Appeal Statement

2 Linksway, Northwood, London, HA6 2XB

Householder Appeal against the refusal of part retrospective planning permission for the erection of a part two storey, part first floor side extension, single storey rear extension, conversion of double garage to habitable use, installation of canopy to front and raising of roof to allow conversion of roof space to habitable use to include 3 rear dormers, 1 front dormer and 2 new gable end windows to front

AS BUILT FIRST FLOOR PLAN

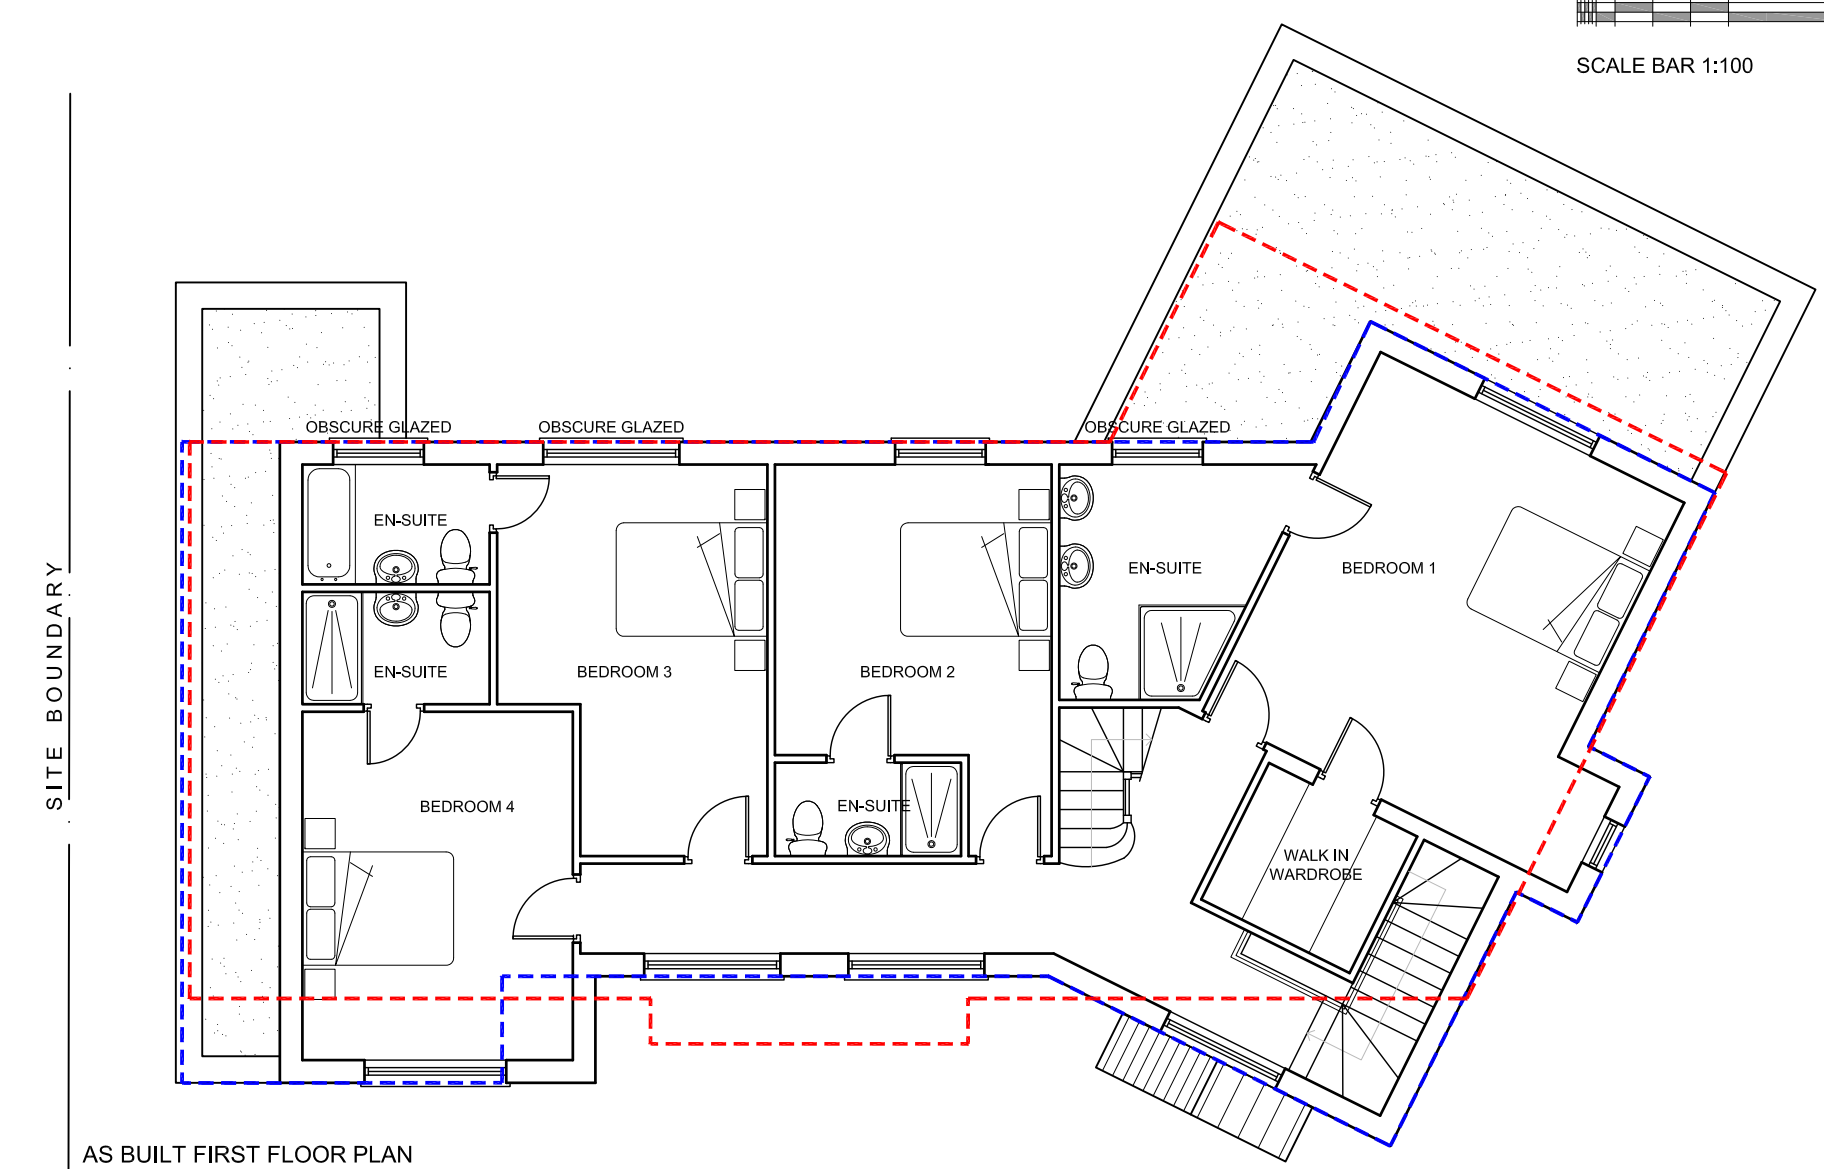
3) The use of obscure glazing within Bedroom 3 (as identified in accompanying plan A203 Revision C) results in a habitable room in the extended property from receiving sufficient daylight and provides that room with an inadequate outlook, to the detriment of the living conditions of that property and the residential amenity of future occupiers. The application therefore fails to comply with Policy BE20 of the Hillingdon Local Plan - Saved Policies.

The Local Planning Authority have stated that the use of obscure glazing within Bedroom 3 results in a habitable room in the extended property from receiving insufficient daylight and provides that room with an inadequate outlook, to the detriment of the living conditions of that property and the residential amenity of future occupiers. However as aforementioned, the extensions approved under planning permission reference: 36910/APP/2015/621 clearly illustrate that the glazing to Bedroom 3 was clear glazed and that no conditions were attached to the planning permission requiring this glazing to be obscure glazed. Nonetheless, as the length of the two-storey southern extension has been reduced by approximately 1.3 metres, resulting in this window now being sited 3.5 metres further to the north and therefore increasing the separation distance between the window and the shared boundary to 9 metres, it is considered unreasonable for this window to be obscure glazed. Notwithstanding the above, should the Planning Inspectorate deem it necessary, the applicant is willing to accept a condition for this window to be obscure glazed and fixed shut up to an internal height of 1.7 metres and this room utilised as a walk in wardrobe or store room. This bedroom can then be relocated to the study at loft level which benefits from east and west facing windows.

AS BUILT FRONT ELEVATION (A)

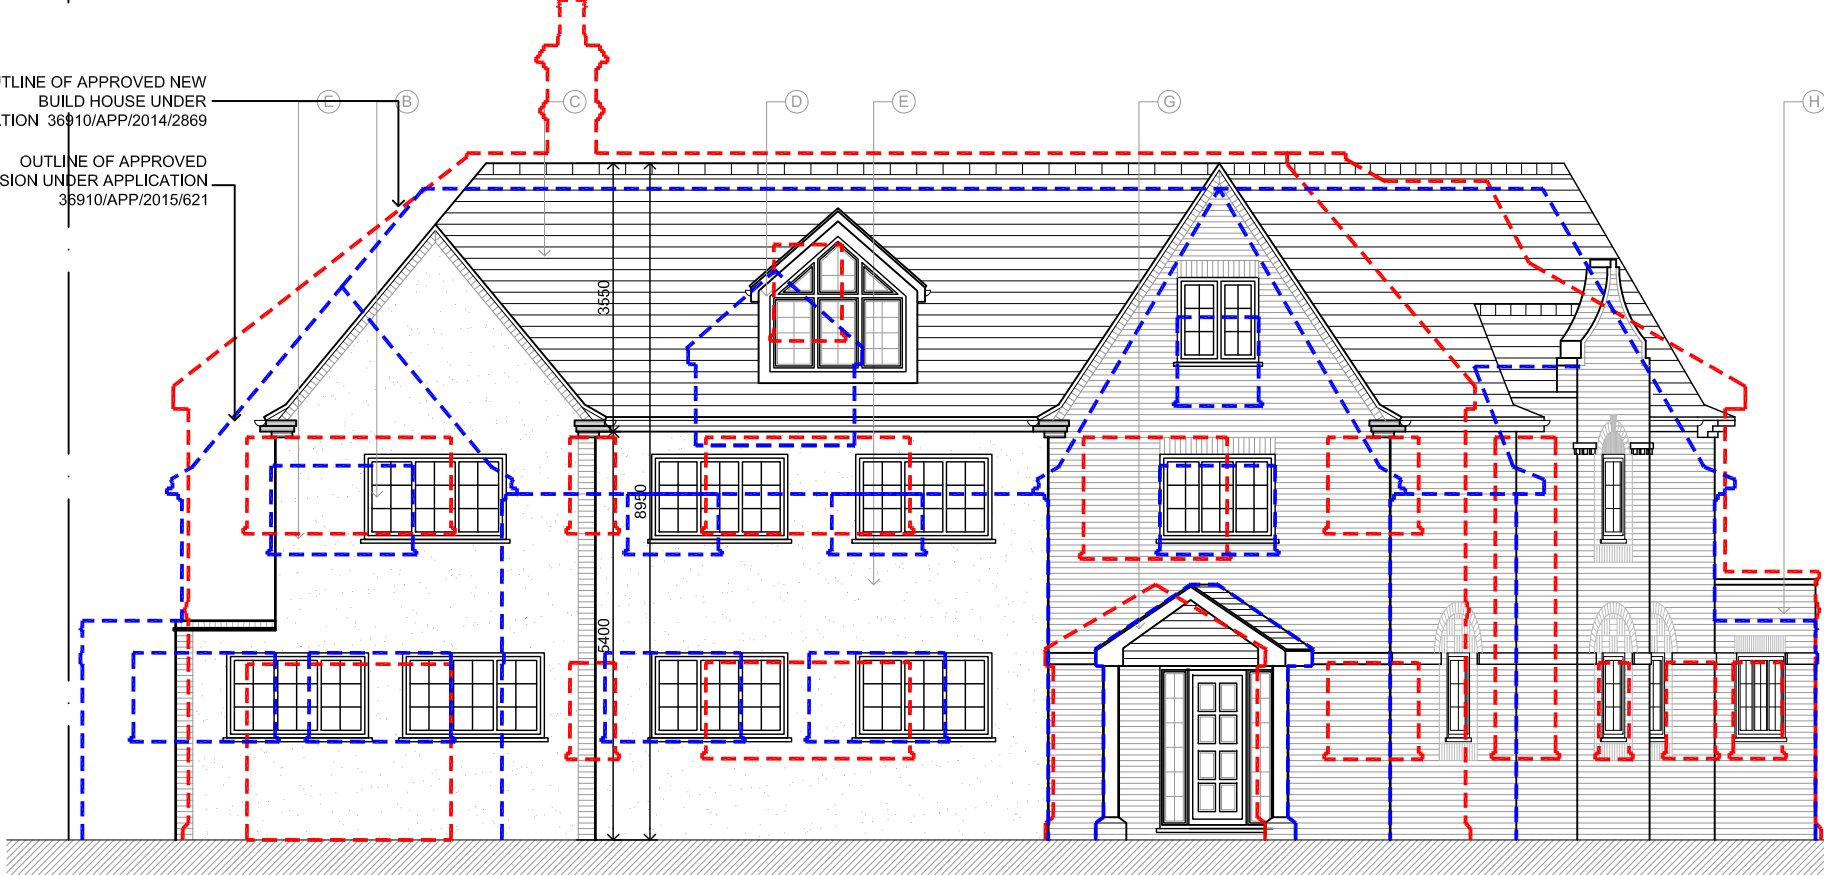
The Planning Officers report states that by raising the eaves, the 'as built' dwelling has vertical walls of an increased height which appear significantly more prominent than in the approved permission and as a result, the building elevations appear more stark and visually prominent. The report goes on to state that the height of the eaves is not matched by an increase in ridge height and this has resulted in a roof form that is shallower than that which was approved and as a result, the proportions of the building have been altered which has resulted in a more prominent and overly dominant structure and has also resulted in the prominence of the various dormer windows being exaggerated to a degree that they are less sympathetic towards the form of the building as a whole.

The Officers report goes on to say that the approved application had the eaves directly above first floor windows, which is a common characteristic of buildings on Linksway and that the increased eaves height has left a gap between the top of first floor windows and the eaves which is not consistent with this distinguishing feature within the surrounding area. In this regard, it is evident that the street scene of Linksway accommodates a number of architectural styles, with many dwellings incorporating a gap between the first floor windows and the eaves. The gap between the top of the first floor windows and the eaves of the appeal dwelling is only 30 centimetres which is a standard degree of spacing. Below are a few examples of neighbouring dwellings along Linksway which have significantly greater gaps between the top of their respective first floor windows and the eaves:

AS BUILT REAR ELEVATION (D)

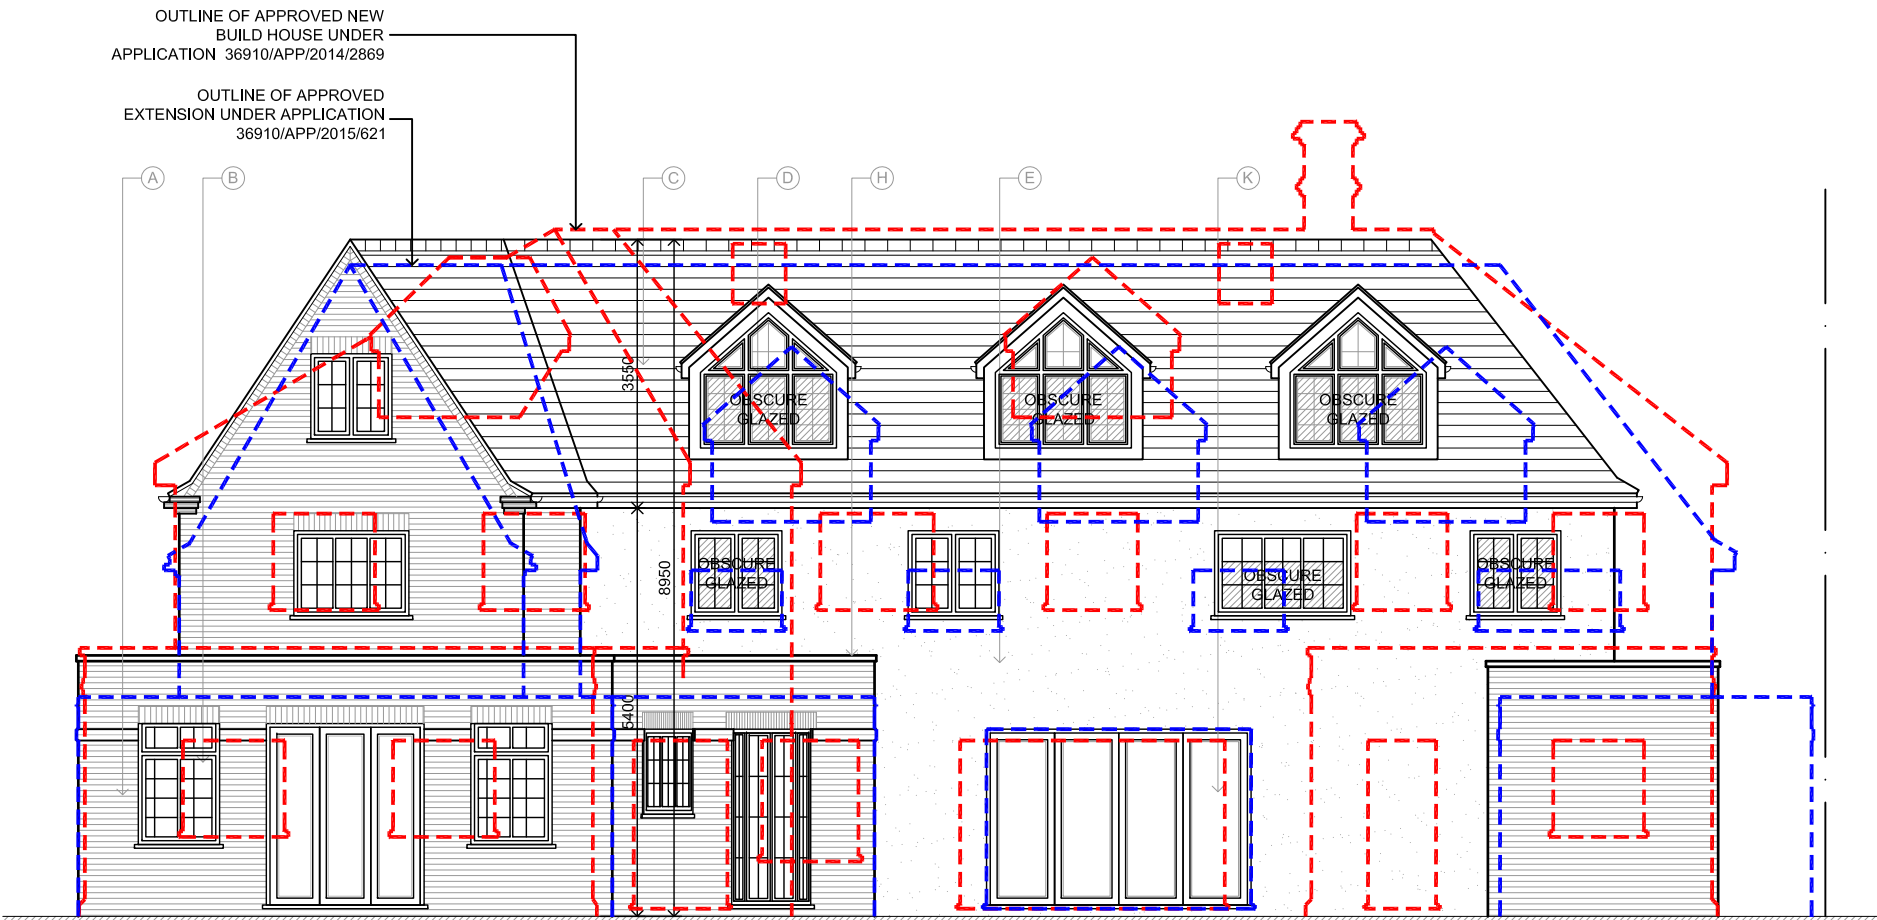
2) The 'as built' alterations to the extension by reason of the proximity, siting, size of the windows and internal are considered to overlook the private garden of No. 3 Copse Wood Way to an unacceptable degree, to the detriment of these occupiers. The proposed obscure film applied to the overlooking windows and the ability for those windows to be opened are not considered to provide a sufficiently permanent or robust means of mitigating the overlooking of the neighbouring rear garden. The application would thereby erode the privacy and living conditions of these occupants to an unacceptable degree. Further, the increase in the height of the extensions would result in a scheme that would appear unduly dominant and visually overbearing to the detriment of the amenities of No. 3 Copse Wood Way. The application therefore fails to comply with the NPPF, Policies BE21 and BE24 of the Hillingdon Local Plan: Part Two - Saved Policies and HDAS 'Residential Extensions'.

The Local Planning Authority have stated that the 'as built' alterations to the extension by reason of the proximity, siting, size of the windows and internal arrangement are considered to overlook the private garden of No. 3 Copse Wood Way to an unacceptable degree, to the detriment of these occupiers. Further, the increase in the height of the extensions would result in a scheme that would appear unduly dominant and visually overbearing to the detriment of the amenities of No. 3 Copse Wood.

The window serving the en-suite to bedroom 3 has been fitted with obscure glazing in order to protect the privacy No. 3 Copse Wood Way. With regards to the rear dormer windows serving bedroom 5, although no condition was previously attached to the permission for these to be obscure glazed, the applicant has willingly installed obscure film and a locking mechanism in order to protect the privacy No. 3 Copse Wood Way. This bedroom benefits from a dormer to the front roof slope and as such, benefits from a satisfactory degree of outlook. It is therefore considered that the internal arrangement of the extension as built improves the spatial relationship with No. 3 Copse Wood Way. Furthermore, the applicant, without any obligation or enforced by planning condition, has installed obscure glazing to the rear dormers and moved the bedroom 3 window further away. Notwithstanding the above, the applicant is willing to accept a condition for the two rear dormers windows serving bedroom 5 to be obscure glazed and fixed shut up to an internal height of 1.7 metres as this bedroom benefits from an east facing clear glazed dormer.

The Local Planning Authority have also stated that the increase in the height of the extensions would result in a scheme that would appear unduly dominant and visually overbearing to the detriment of the amenities of No. 3 Copse Wood Way. The rear elevation of the appeal dwelling faces west towards the flank elevation of the dwelling at No. 3 Copse Wood Way and the rear aspects and garden of this property faces south-east. As such, when viewed from the rear aspects of this property, the appeal dwelling does not fall within the direct line of site. The submitted plans demonstrate that the two storey element of the dwelling does not breach a 45 degree line of vision from the ground floor near side window of No. 3 Copse Wood Way. Furthermore, the dwelling does not encroach any closer to the south-western boundary and is built with the same rear building line as the previously approved scheme under reference: 36910/APP/2015/621.
